University of Western Sydney
Parramatta Campus

Indigenous Centre of Excellence

Sydney, 18th February, 2025
Ref. No. 237139-co-E02

Utility Services Response to Submissions

DRAWING NUMBER
DA 1-102

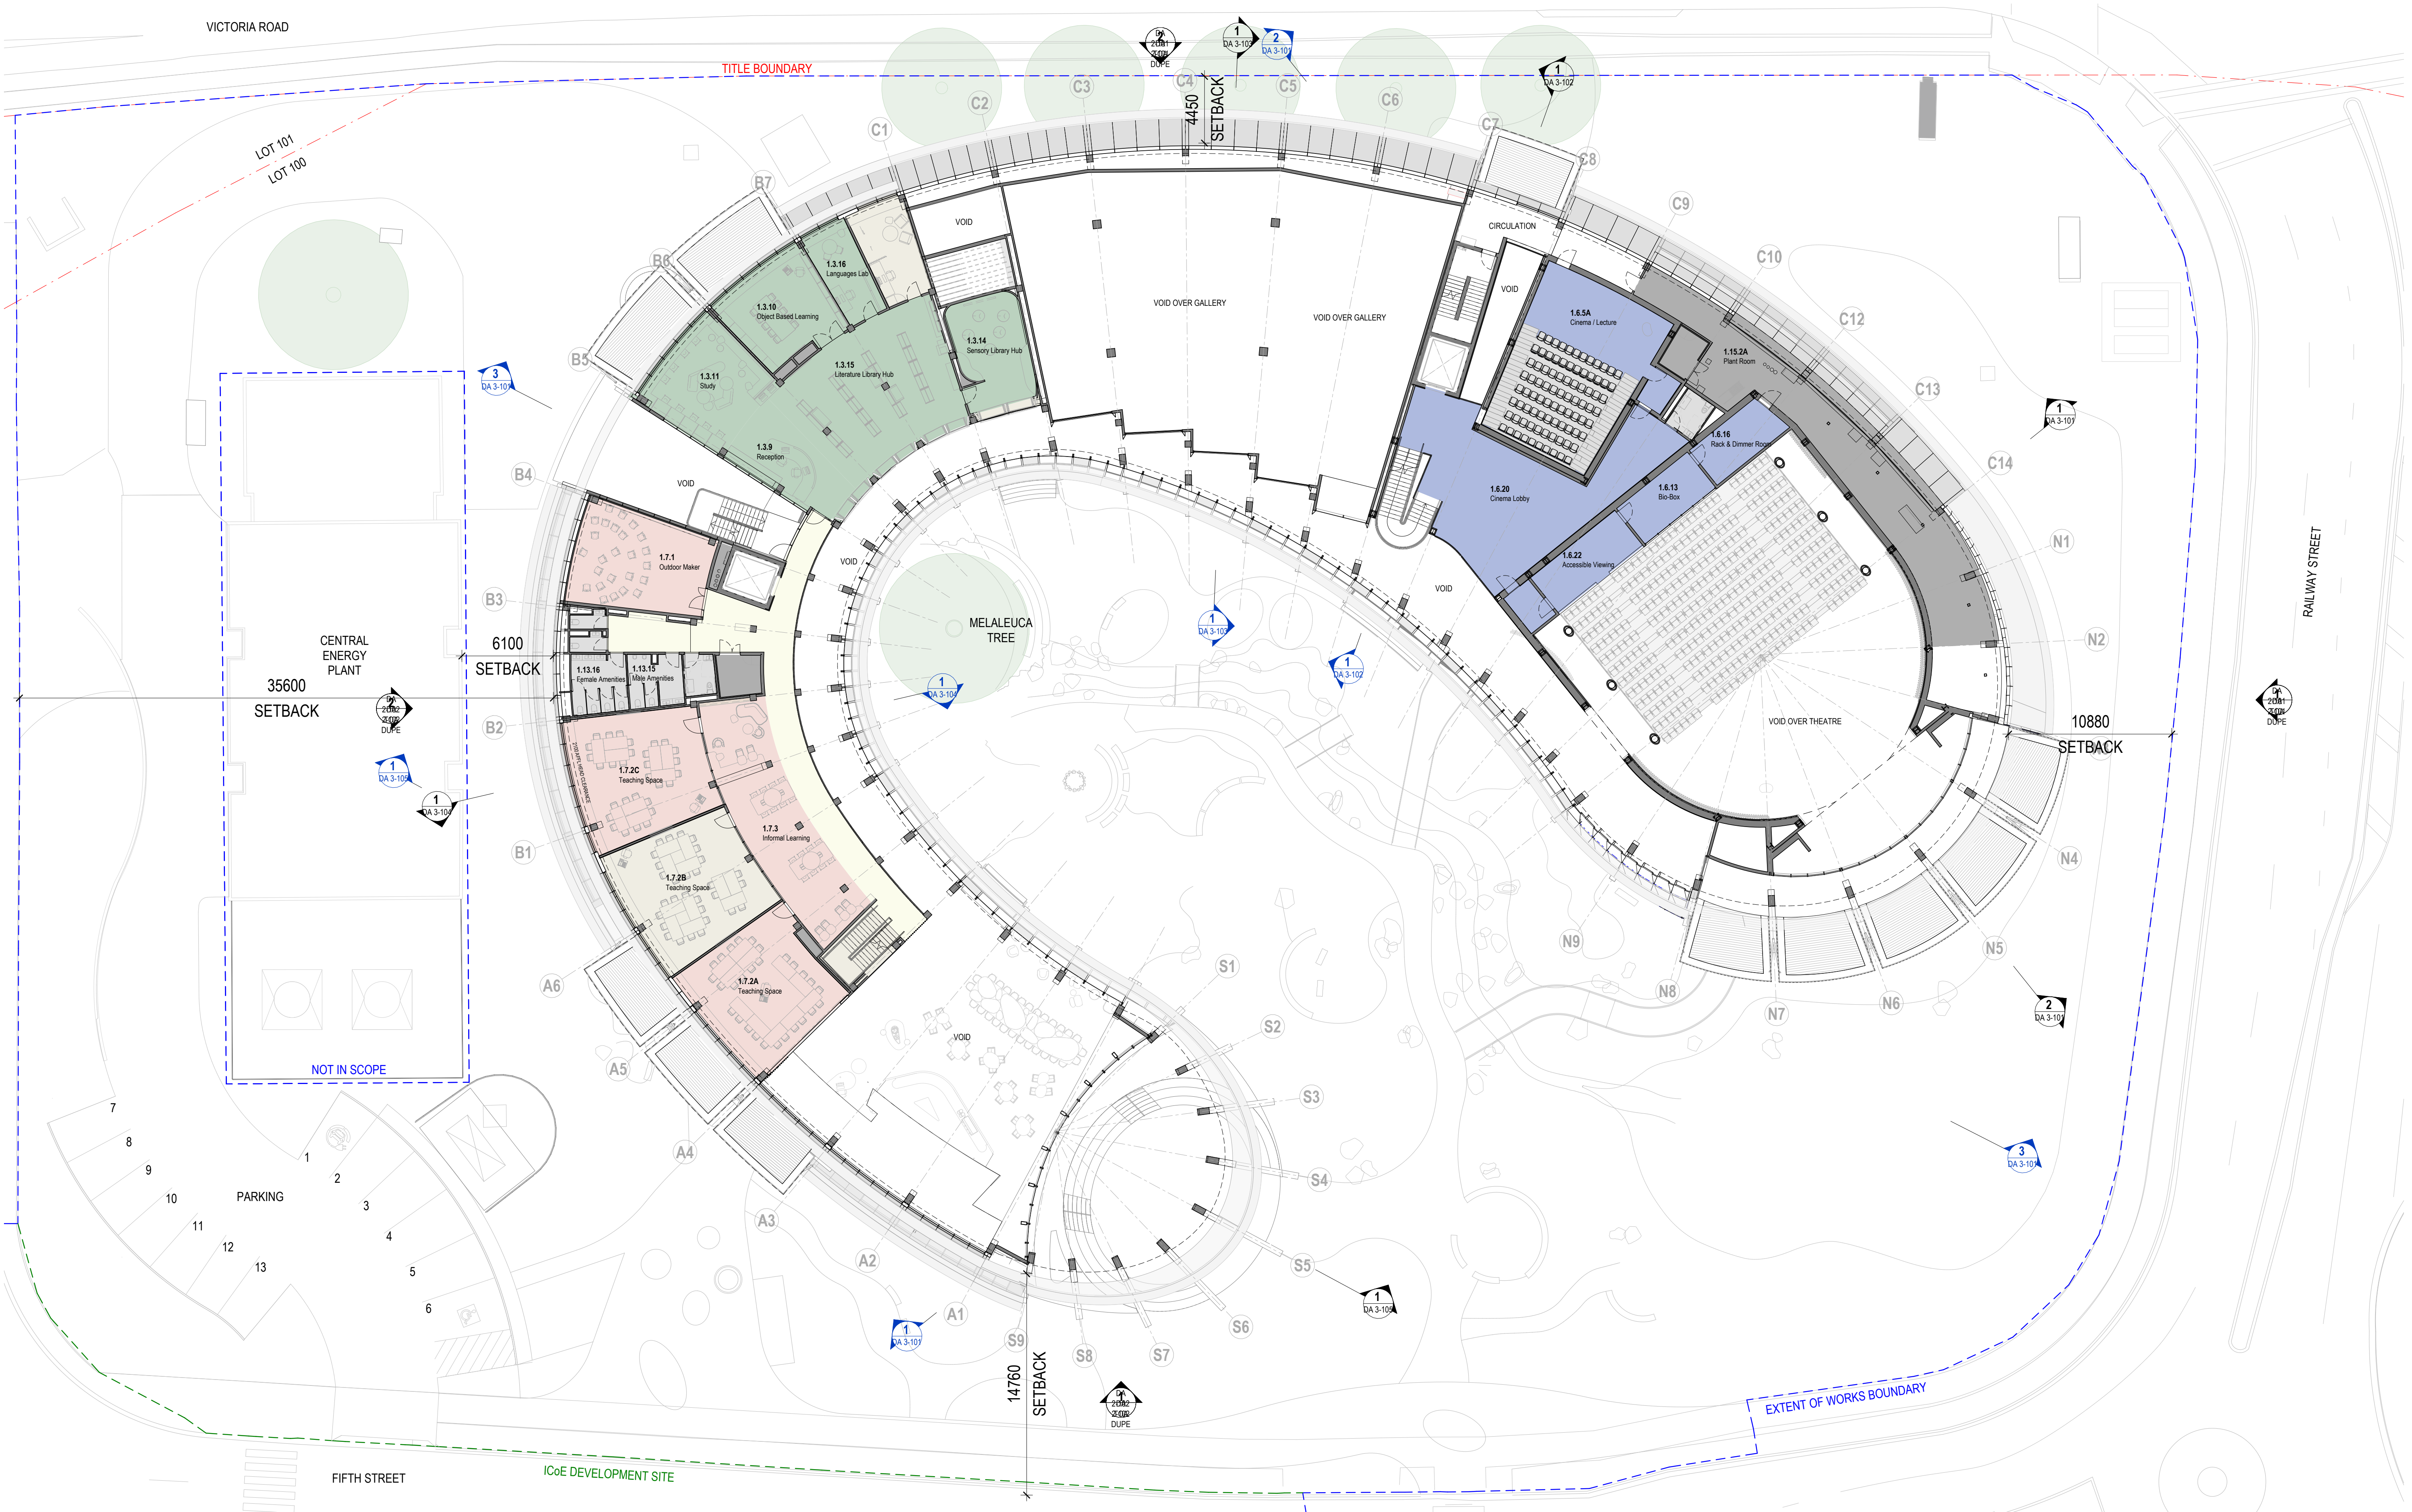
Endeavour Energy - Endeavour Energy's network asset design policy is generally to progressively underground all new urban developments. All new cabling / reticulation infrastructure must be of an underground construction type. Where existing overhead construction is present on or in proximity of the site, it may require undergrounding as the development proceeds.	Design of Endeavour Energy network augmentation would be subject to Endeavor Energy Connection Offer and ASP 3 approved design., if this option is directed by the University.
Endeavour Energy - The Electrical Utility Statement prepared by Steensen Varming dated 8 May 2024 is in keeping with the foregoing. The Architectural Drawings do not appear to show provision for the 'new pad mount substation'.	Substation is shown on drawing DA 1-102 revision 1
